February 28, 2017

**EPC APPROVAL June 9, 2016  
CONDITIONS OF APPROVAL 16 EPC-40007  
RESPONSE TO CONDITIONS**

DATE: 2-23-2017
SHEET NUMBER: TCL-1.0

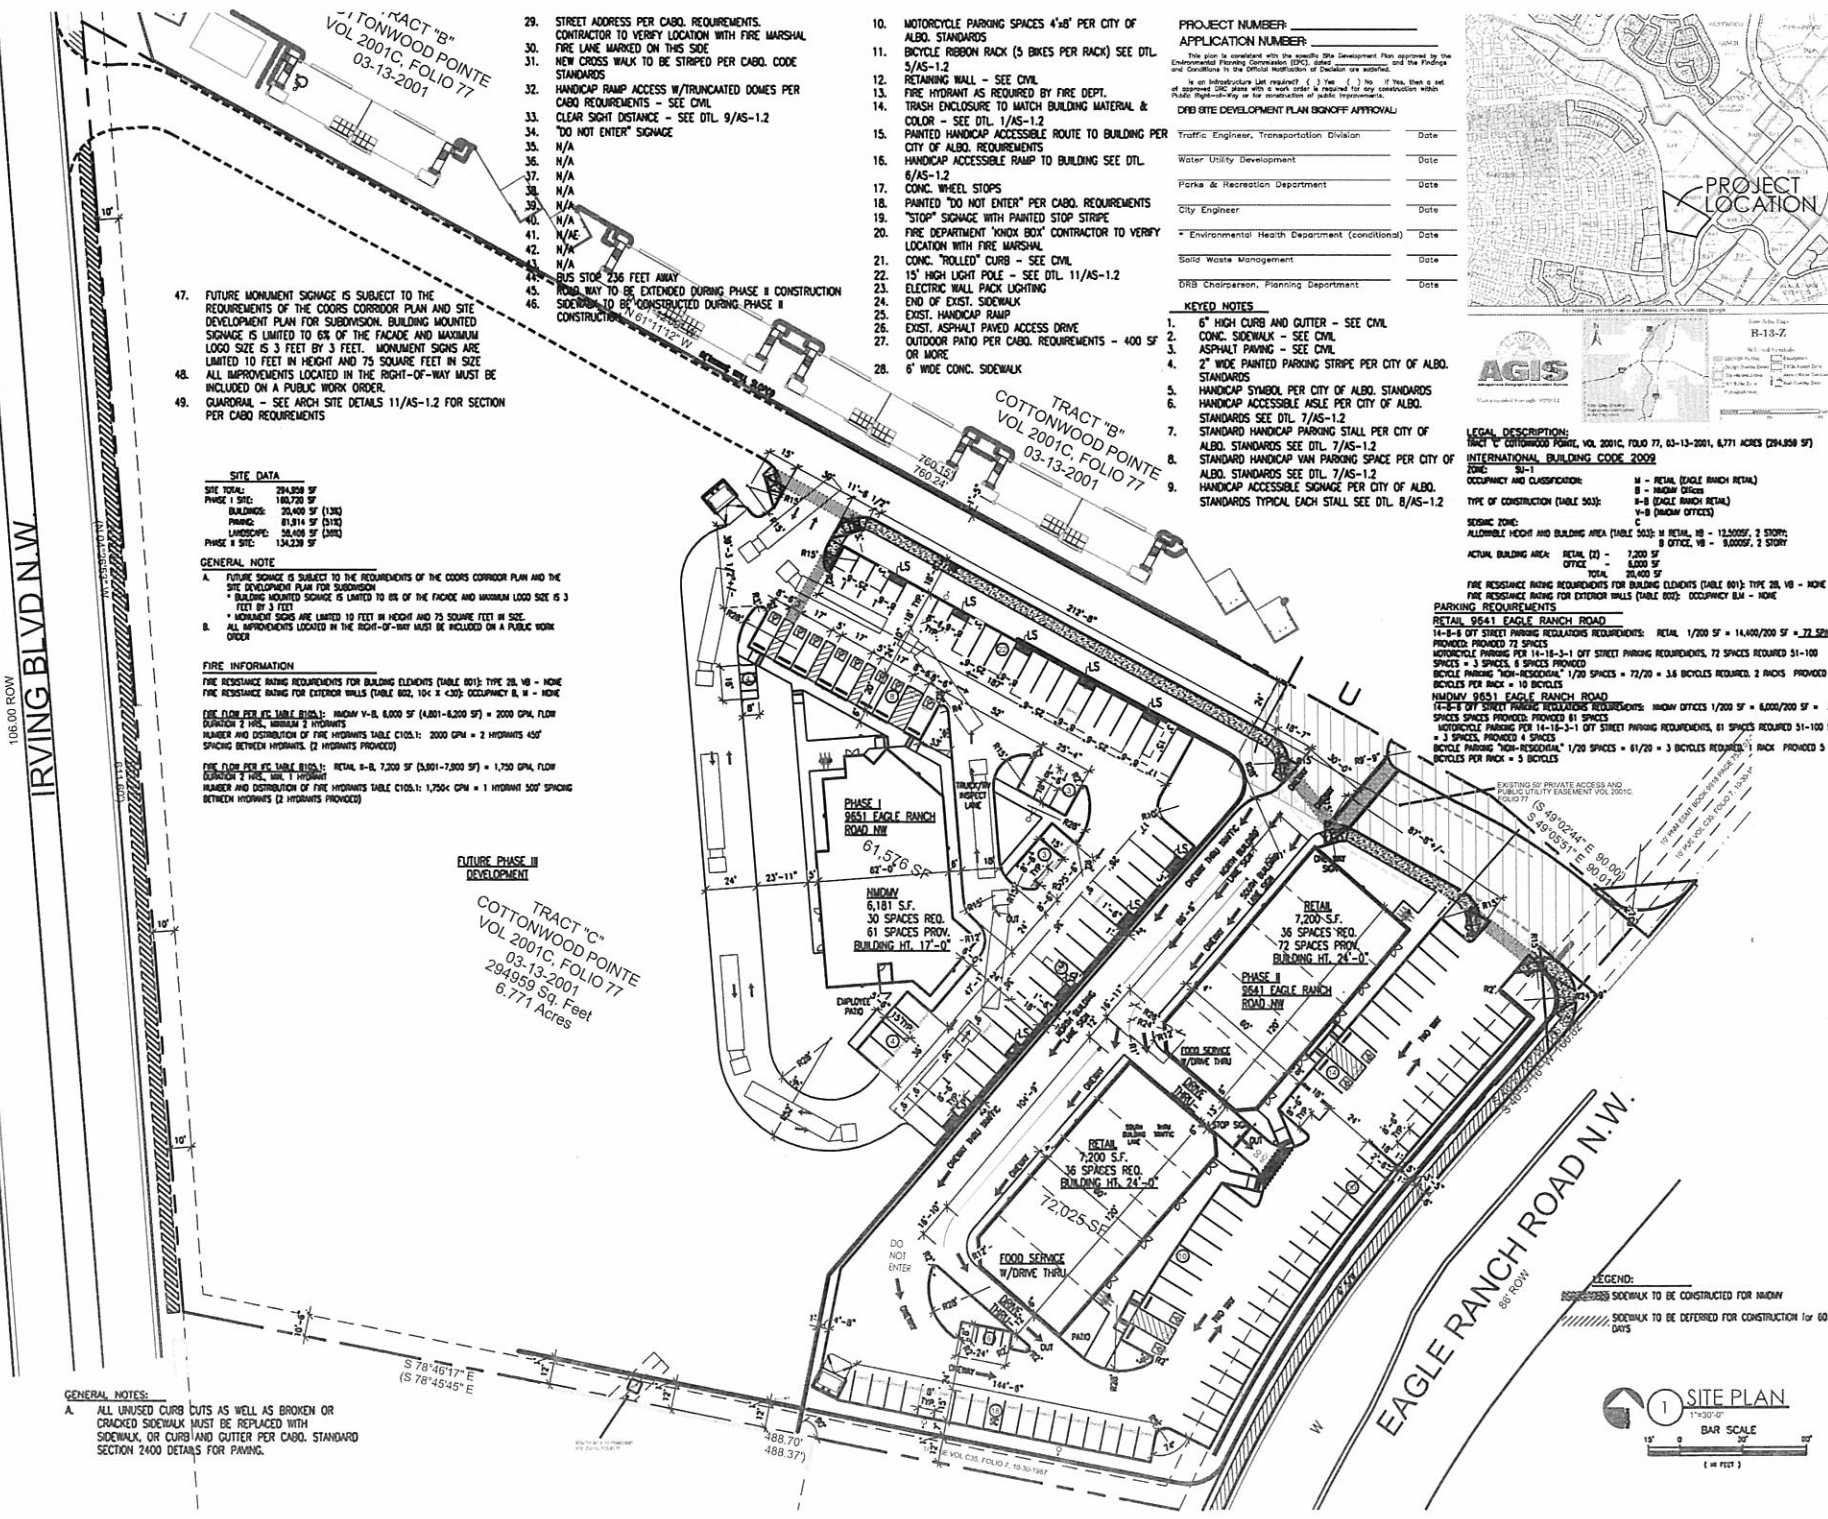
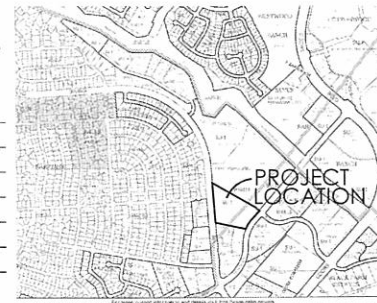
**Response:** Have met with planner and made changes to site plan per their comments.
3. Clarify 141 vs 142 parking spaces shown on sheet TCL-1.0  
Access has been clarified.

**Response:** parking has been clarified.
4. Add a note to sheet TCL-1.0 stating that future signage is subject to the requirements of the Coors Corridor Plan and the Site Development Plan for Subdivision.

- Building Mounted Signage is limited to 6% of the façade and maximum logo size is 3 feet by 3 feet.
  - Monument sign are limited 10 feet in height and 75 square feet in size**Response:** Note has been added to plan. Building mounted signage will comply. No monument sign is planned for now.

**Response:** Access has been clarified along with added signage.
- Please list the width and length for all parking spaces. Regular parking spaces are required to be a minimal of 8.5 ft. by 18ft. and compact spaces 8ft. x 15ft.

**Response:** Spaces have been dimensioned.
- Label the compact parking spaces by placing the words "COMPACT" on the pavement of each space.  
**Response:** Spaces have been labeled.

**Response:** Everything has been identified.
- Parking spaces cannot overhand ADA access ramps or ADA pathway. Please add wheel stops at ADA parking spaces to HC parking spaces north of proposed NMDMV Building.

**Response:** Wheel stops have been added.
- The ADA accessible parking sign must have the required language per 66-7-352,4C NMSA 1978 "Violators are Subject to a Fine and/or Towing".

**Response:** Has been shown on plan.
- One-way vehicular paths require pavement directional signage and a posted "Do Not Enter" sign at the point of egress. Please show detail and location of directions signs.

**Response:** Has been shown on drawing.
- Please add the following note to the clear sight triangle: "Landscaping and signage will not interfere with clear sight requirements. Therefore, signs, walls, trees, and shrubbery between 3 and 8 feet tall (as measured from the gutter pan) will not be acceptable in this area".
